Subject: Discharge of Planning Conditions Lingards Road - Application Number 2023/44/93464/W

Client				
SB HOMES				
Project				
LINGARD ROAD, SLAITHWAITE				
Detail				
SECTION THROUGH PLOT 36				
Dwn	Chkd	Date	Scale	Dwg No.
IM	MH	NOV23	1:50@A1	7567_200

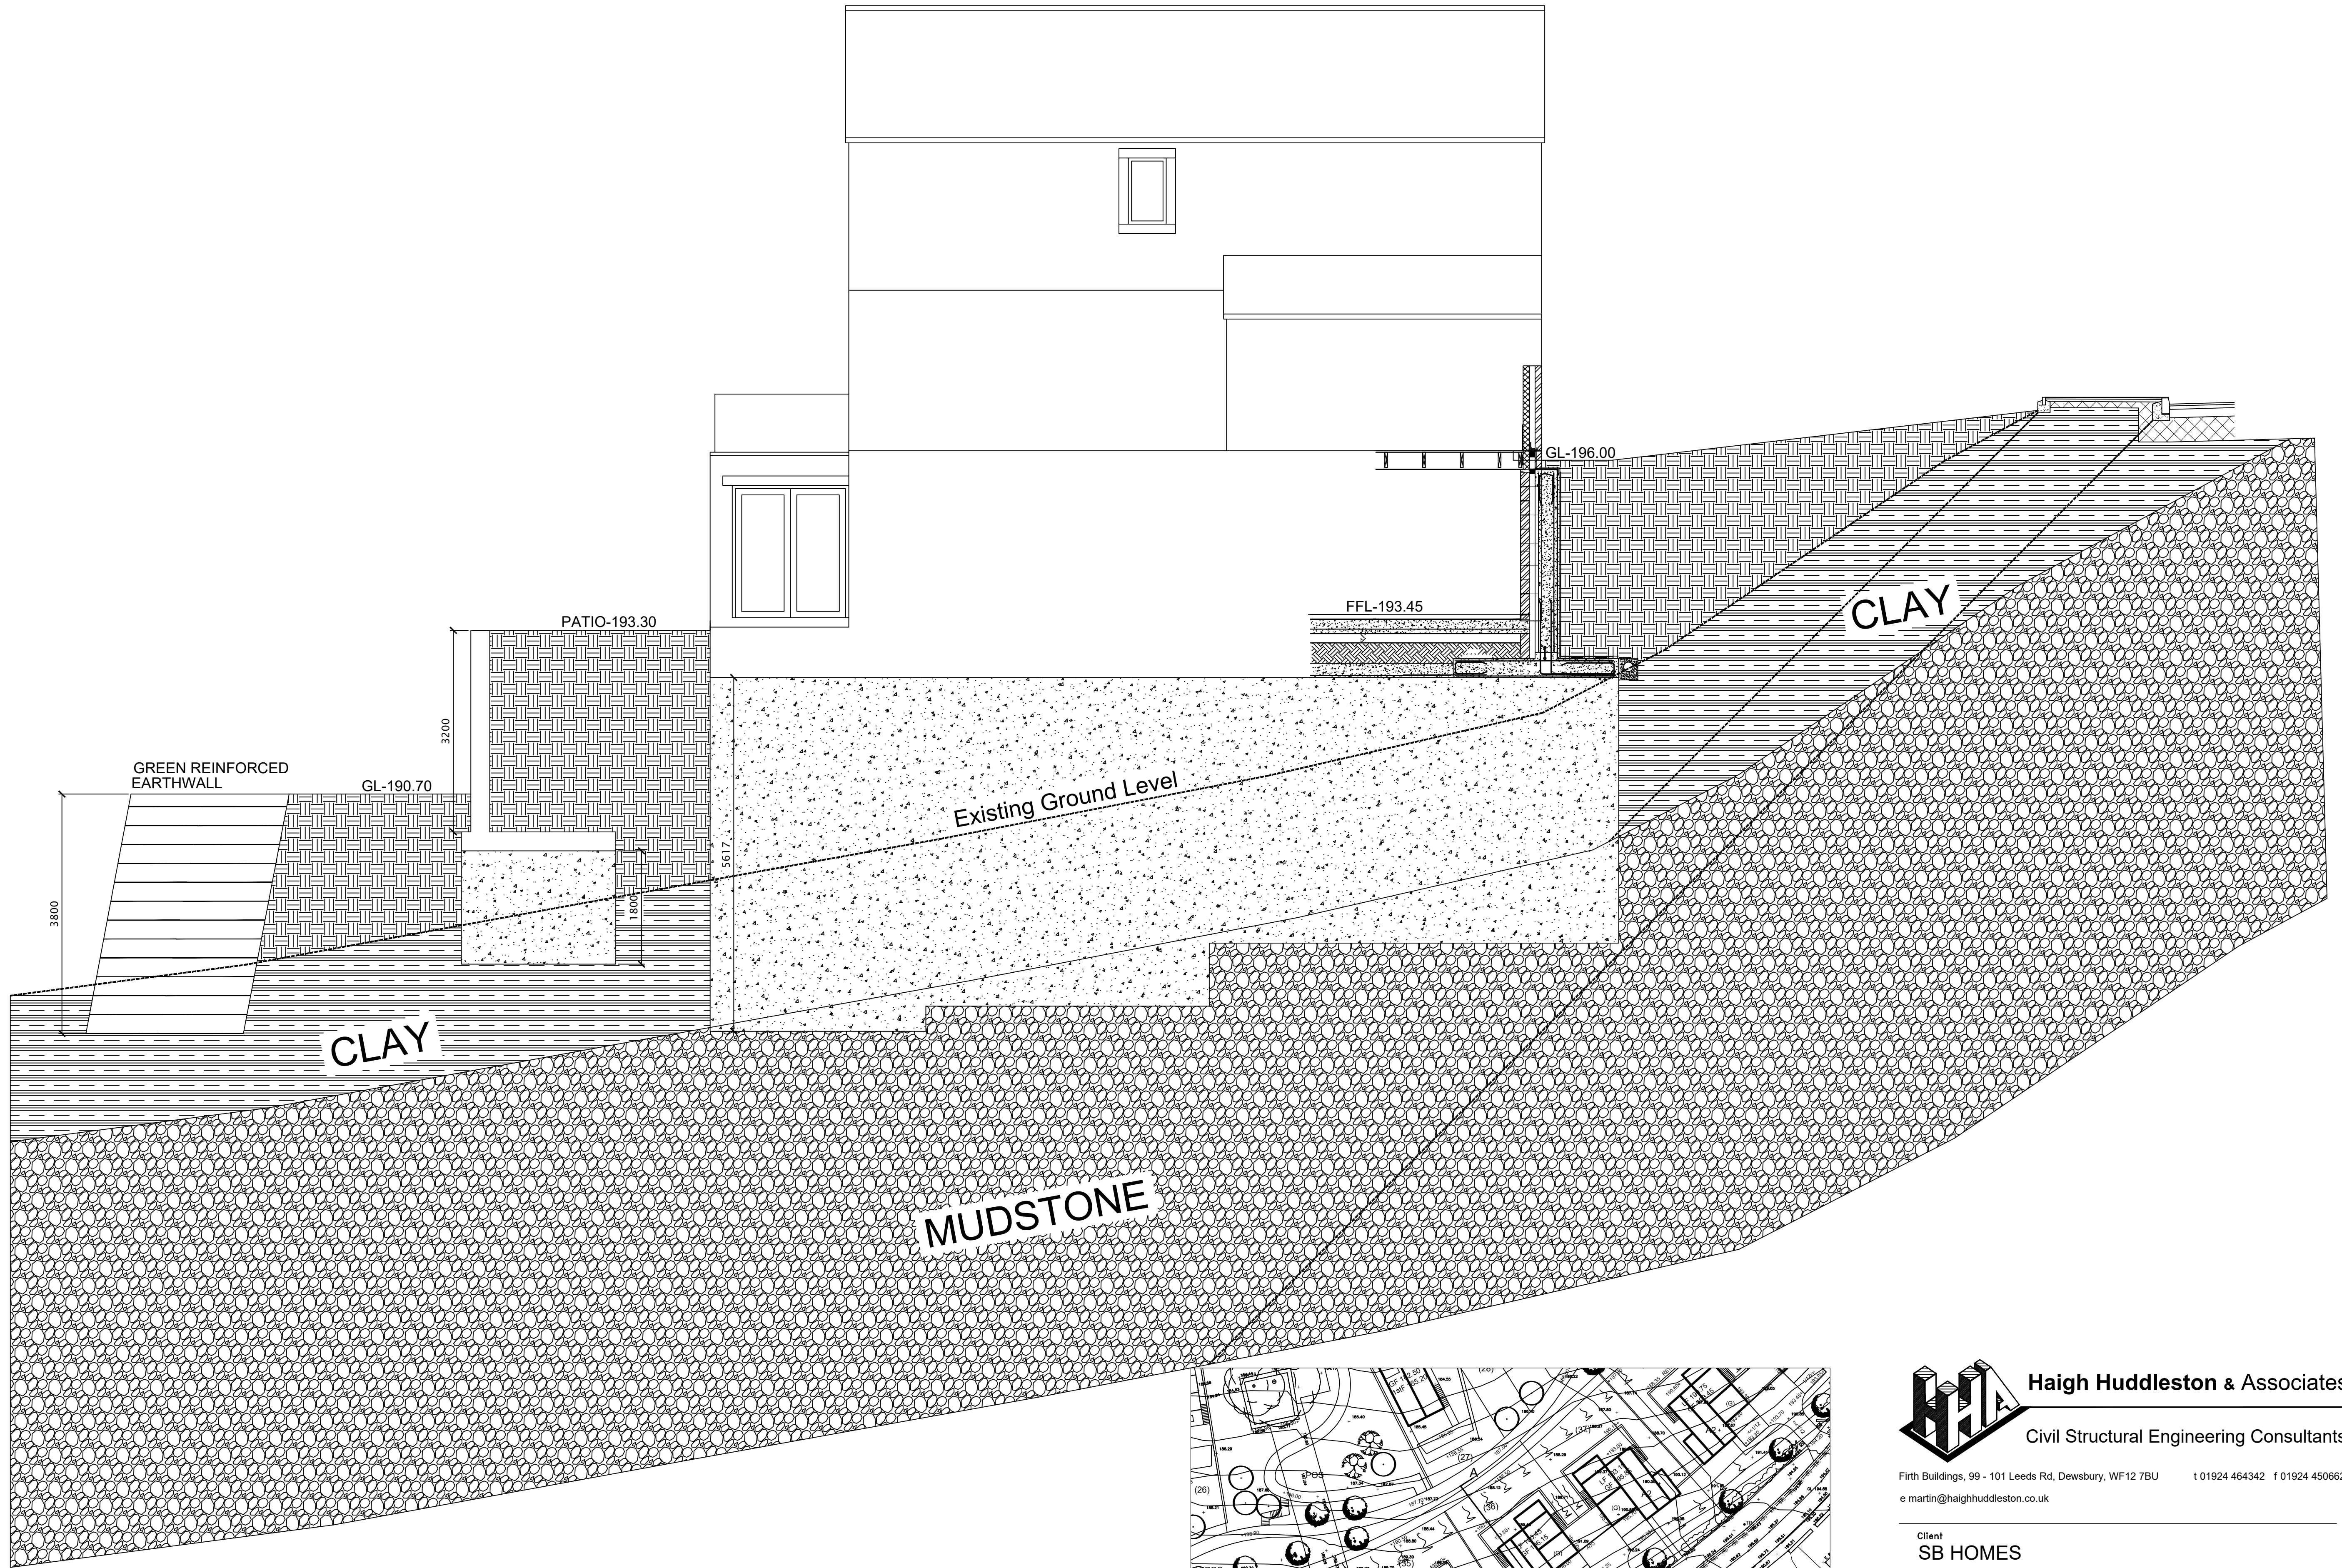
- The structural stability survey looks professional but it only relates to the stability of the naturally occurring subsoil and geology. The investigation borehole towards the extreme South West of the site is not representative of the condition and size of the embankment supporting Lingards road further down the road. There is no mention of the crudely tipped demolition material which forms the banking immediately adjacent to Lingards Road and none of the boreholes / trial pits shown on drawing no E19/7567/037/018 are positioned to assess this problem.(as specifically required by one of the planning conditions) Properties fronting onto Lingards Road will encounter this loosely tipped demolition material during their construction. With the removal of vegetation along the boundary, by the applicant shortly before Christmas, the composition of this unstable embankment is now visible for all to see. (As is the cracking in the existing road surface on top of the loosely tipped fill material opposite house numbers 82 and 84). This is again something that we have told the applicant and planners about several times; only to be ignored several times.

- As an extension of the previous point, the section through plot number 36 on drawing 7567/200 is not correct, as it does not show the loosely tipped demolition material, which forms the existing embankment up to Lingards Road. Instead it makes unwarranted assumptions about the continuation of the natural clay and mudstone strata. This issue must be resolved before the relevant planning conditions can be discharged, because it affects the structural stability of the new properties alongside Lingards Road and the road itself.
